29 December 2014

Ben Lusher
Manager Key Sites
NSW Planning and Environment
GPO Box 39,
Sydney NSW 2001

RE: Modification to Concept Plan MP06_0171 (Mod 10) and State Significant Development Application SSD 14_6673 for Block 4N, Central Park

Figure 8: The location of the proposed short term car parking (Base source: MP06_0171 MOD9 and applicant's RtS)

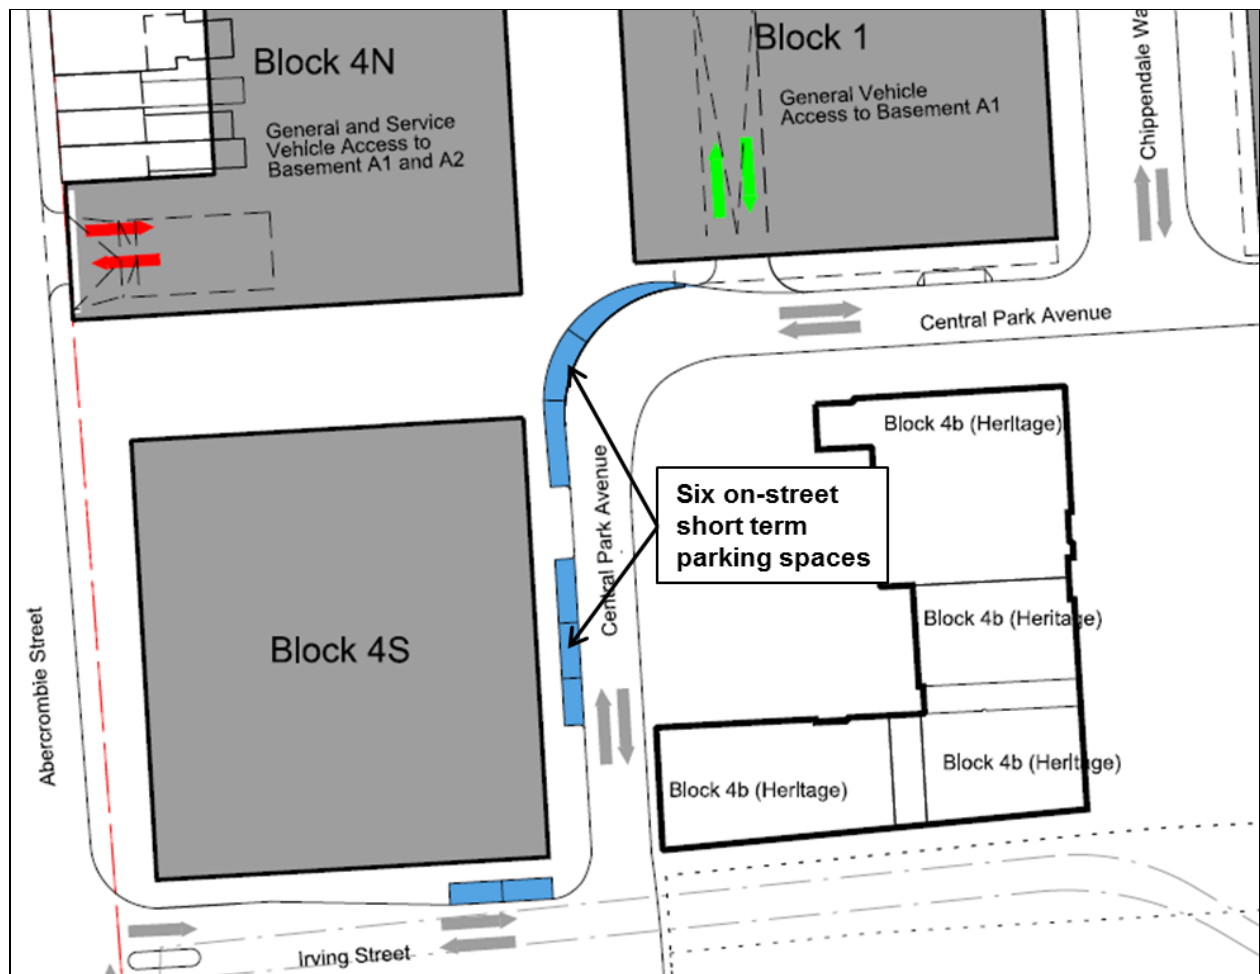
Pick up/drop off spaces for the hotel, including coaches, is not discussed in the traffic report. It is recommended that a condition be imposed to encourage this parking to be provided off-street.

Figure 10: Abercrombie Street frontage, including the Australian Hotel and adjoining terraces, vehicle entrance and through site link (Base source: applicant's EIS)

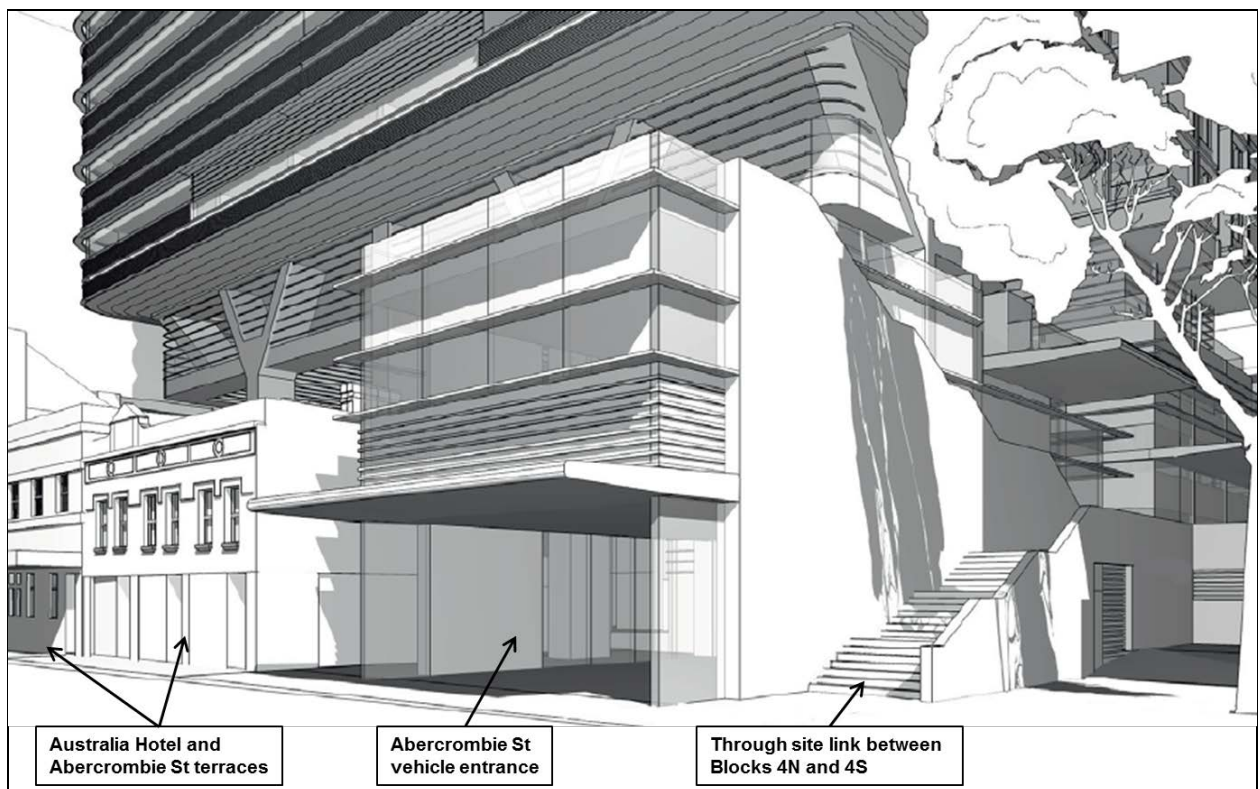
The City requests that the full conservation works to the buildings be undertaken, in particular the terraces which are in extremely poor and derelict condition.
